Arun District Council
Arun Civic Centre
Maltravers Road
Littlehampton
West Sussex BN17 5LF
Planning & Building Control General Enquiries
Tel: (01903) 737756 Fax: (01903) 730442
Dx: 57406 Littlehampton
Minicom: 01903 732765
e-mail: planning@arun.gov.uk
website: www.arun.gov.uk/planning

Application No: FG/169/20/T
Site Address: 41 Ferringham Lane Ferring BN12 5NB
Description of works: Reduction of branch to North Face of Ilex Oak (T1) to 3m and raise crown to 4m above ground level. Removal of dead wood.

Thank you for your internet representation made on 26th January 2021 which has been recorded as an objection with the comments as follows:

SKETCH 1

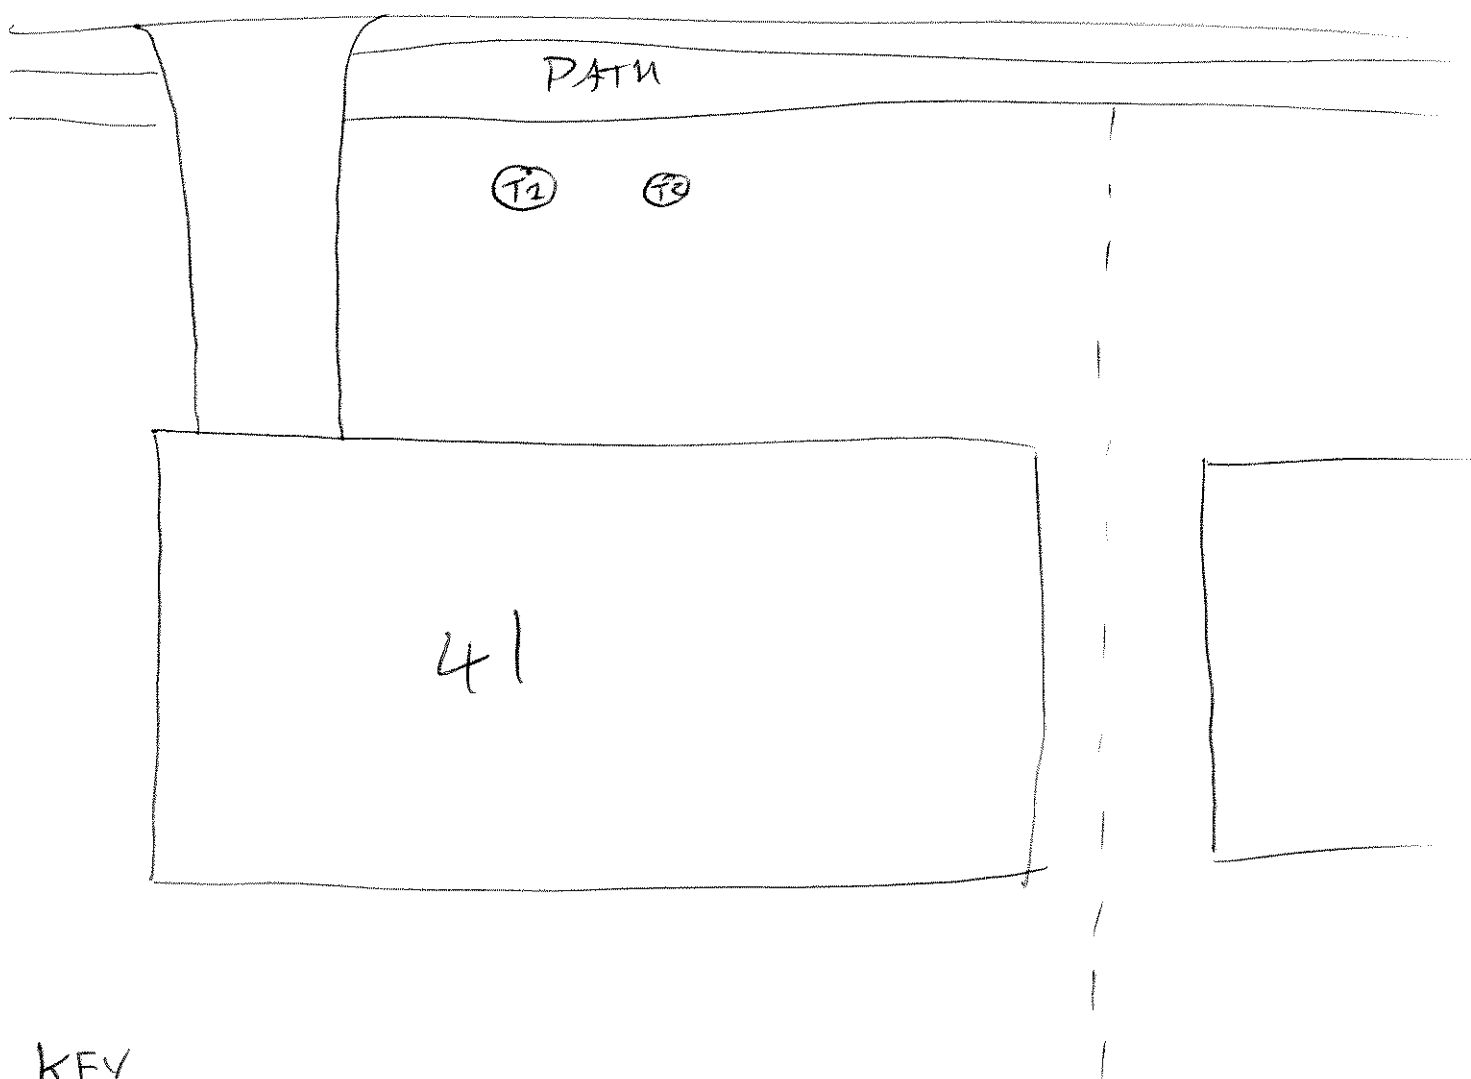
Tree is a Holm Oak 16.5 metres high and has a thin crown compared with similar species nearby, you can see daylight through crown. The canopy is already 3-4 metres above ground level measured from the ground and see no need for the work as high sided vehicles have adequate clearance.

The adjacent poor-quality tree would not be improved by lifting canopy.

The Holm Oak is far more important to the street scene.
